Subject: FW: BR/131/20/PL, Land and Between 2b And 4 London Road Bognor Regis, PP-08781759

Subject: BR/131/20/PL, Land and Between 2b And 4 London Road Bognor Regis, PP-08781759

I am writing in connection with the above planning application which I object to.

PROPOSED FLOOR PLANS

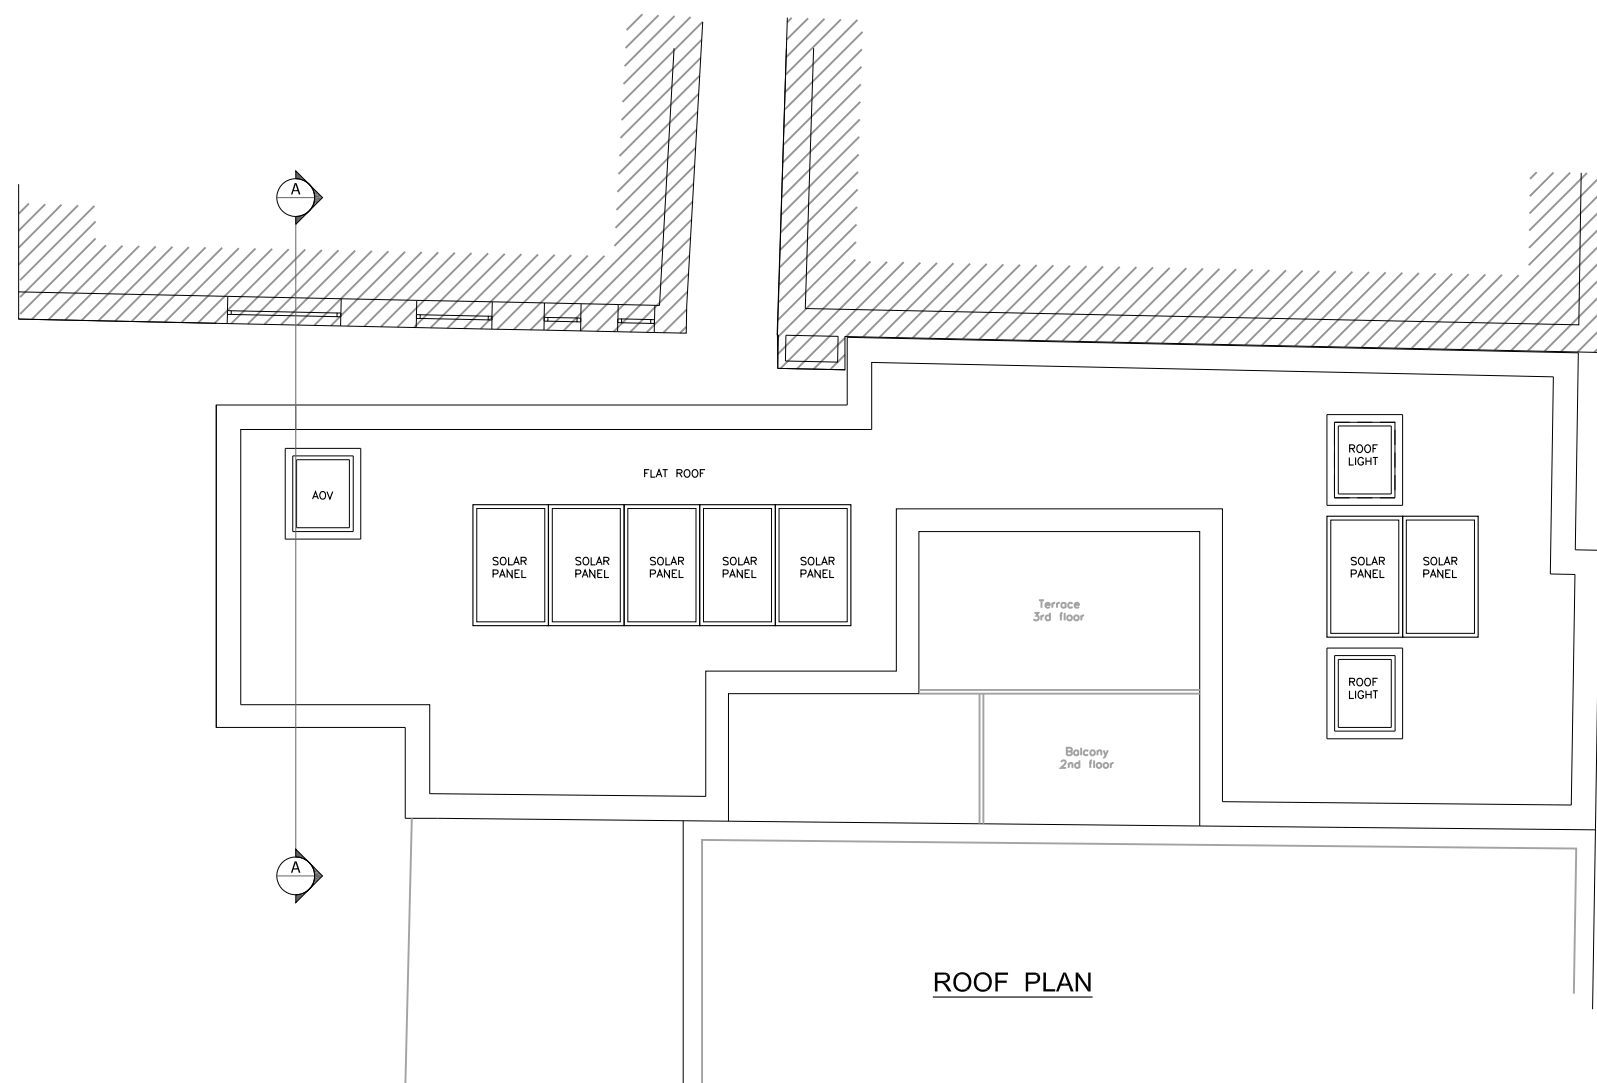
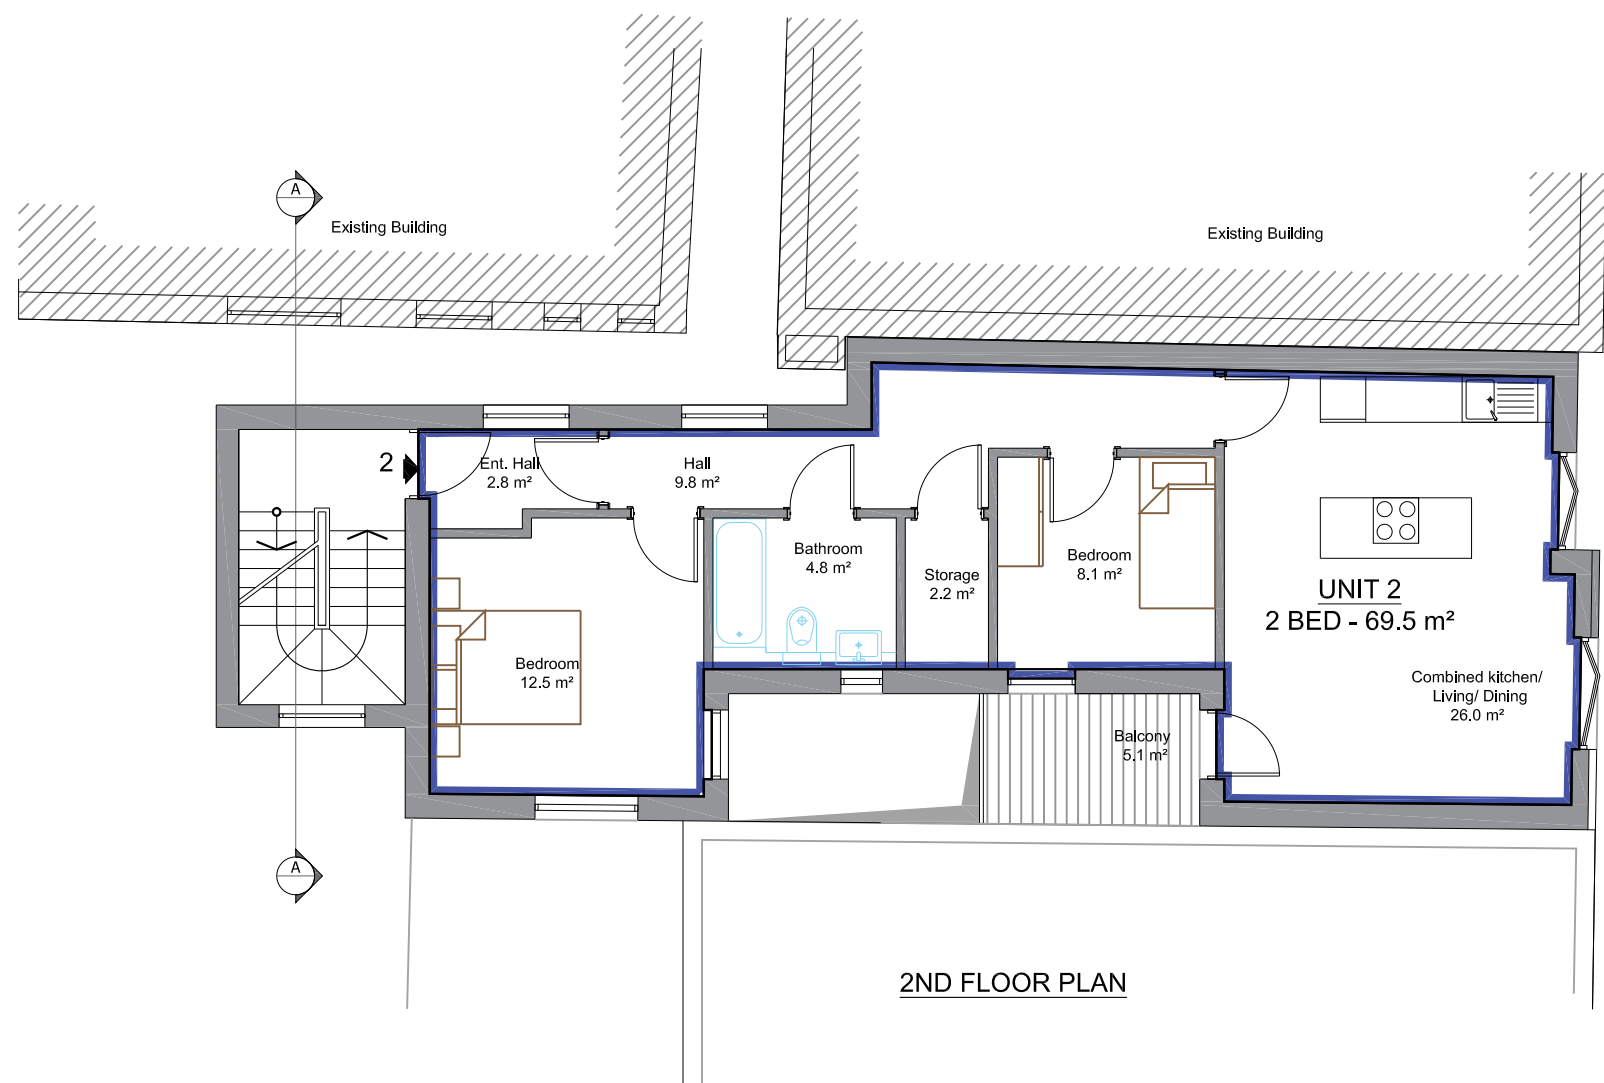
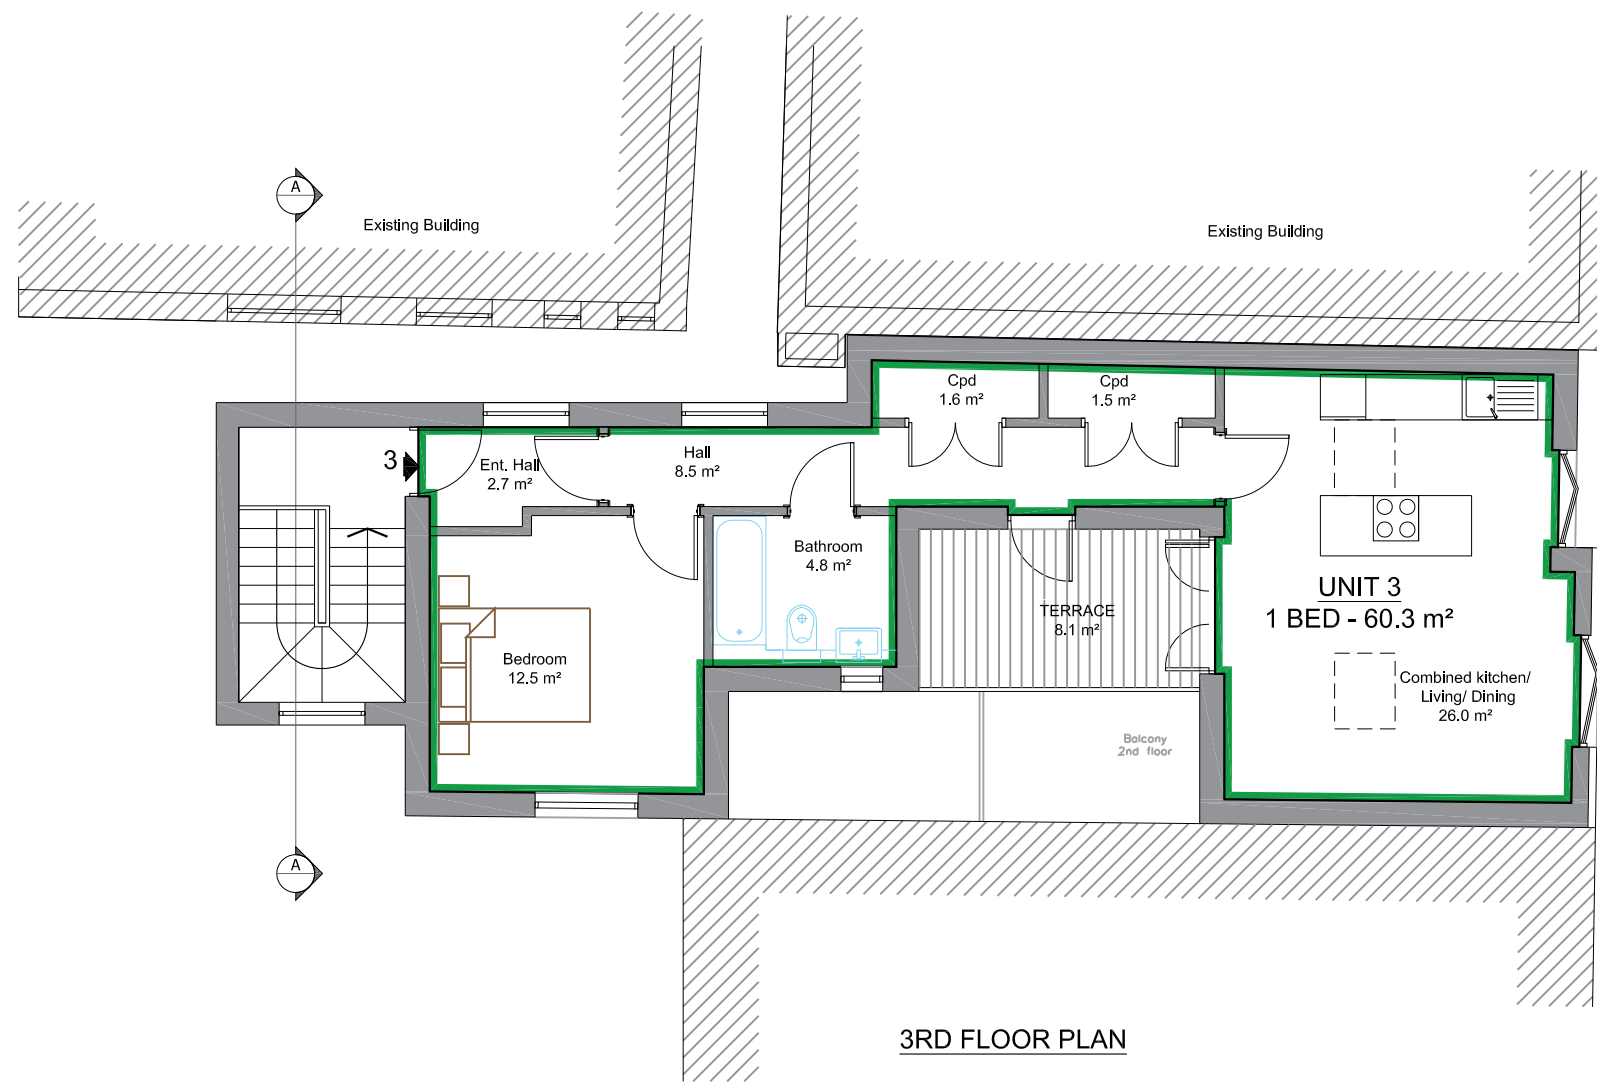
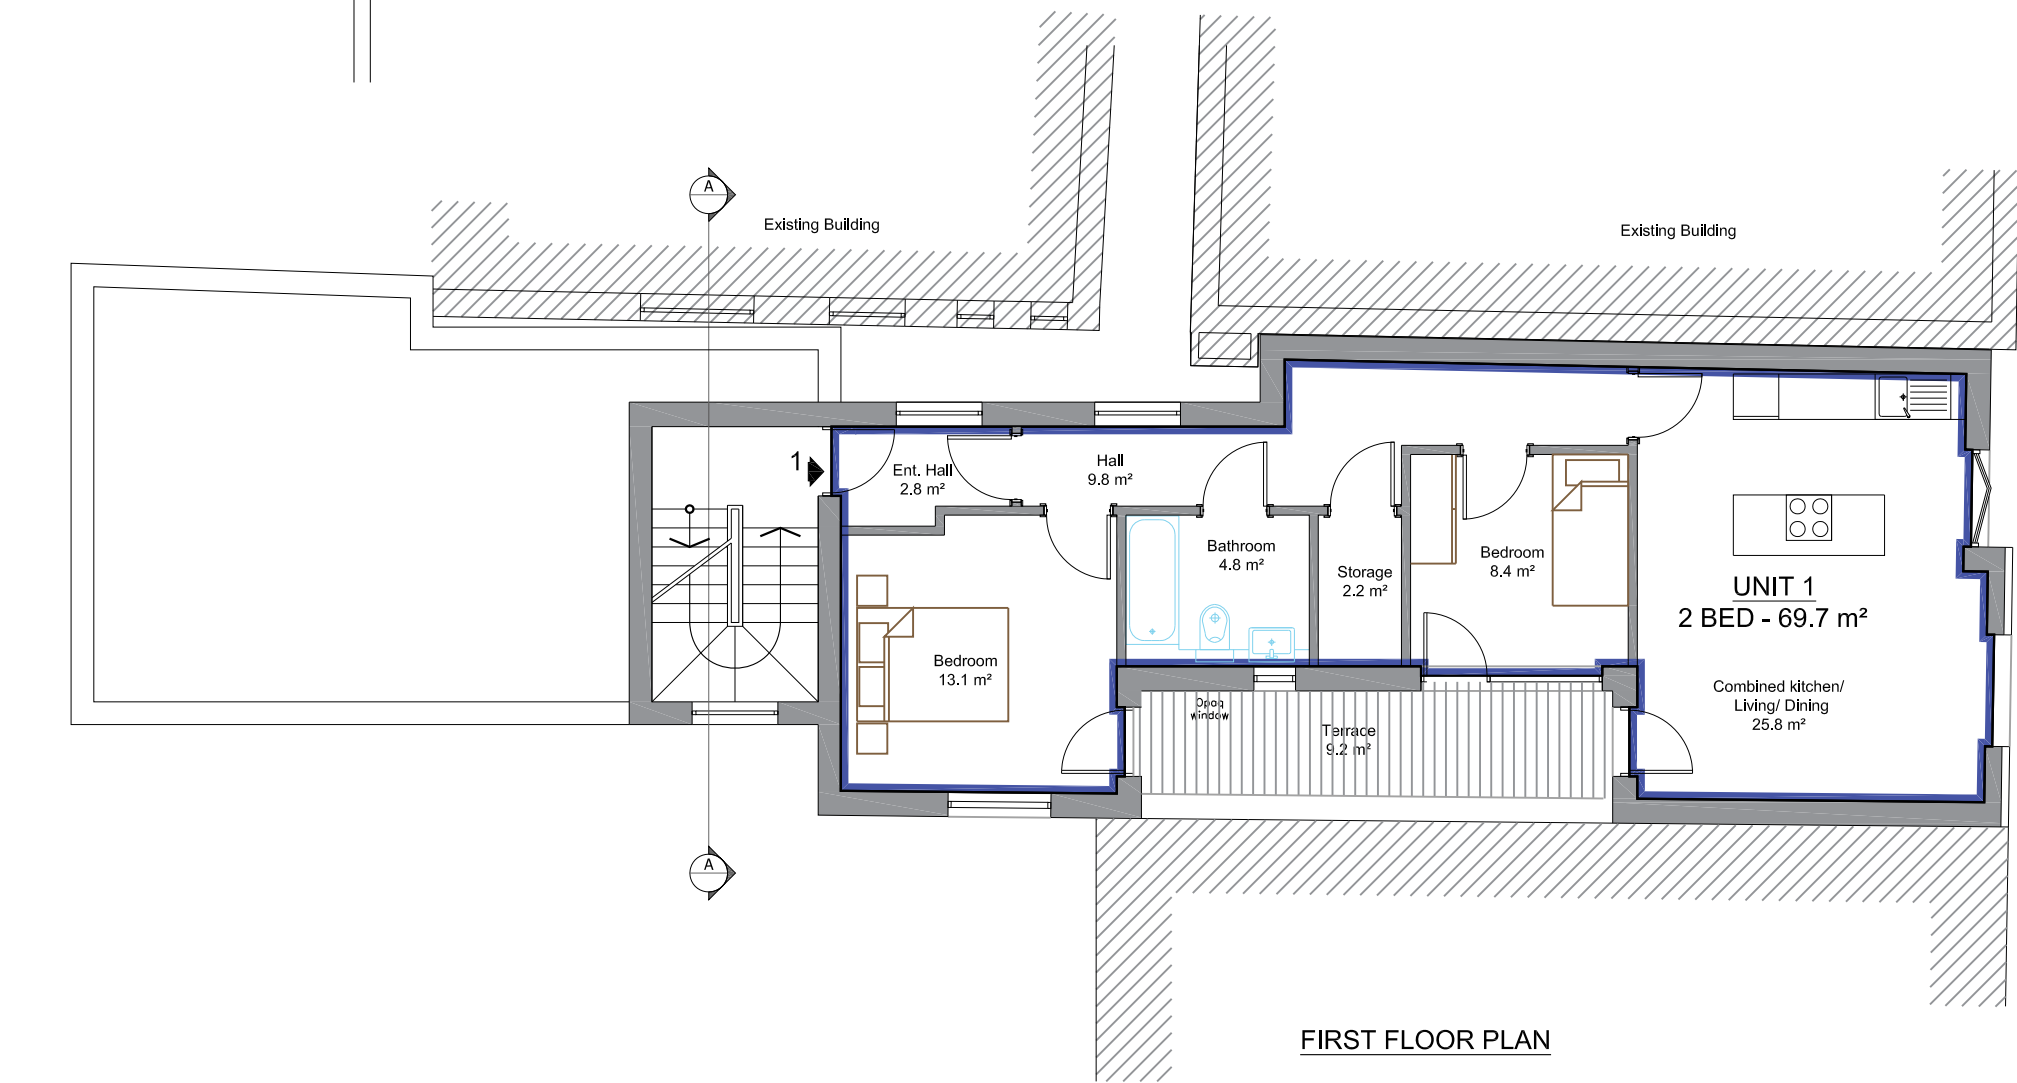
We have a High Court Order dated 1st November 1976 registered on our title deeds in our favour granting a Right of Way over this land which the adjacent owner intends to build over. Furthermore, this planning application would block the rear yard fire exit for our commercial units and also access to the bins.
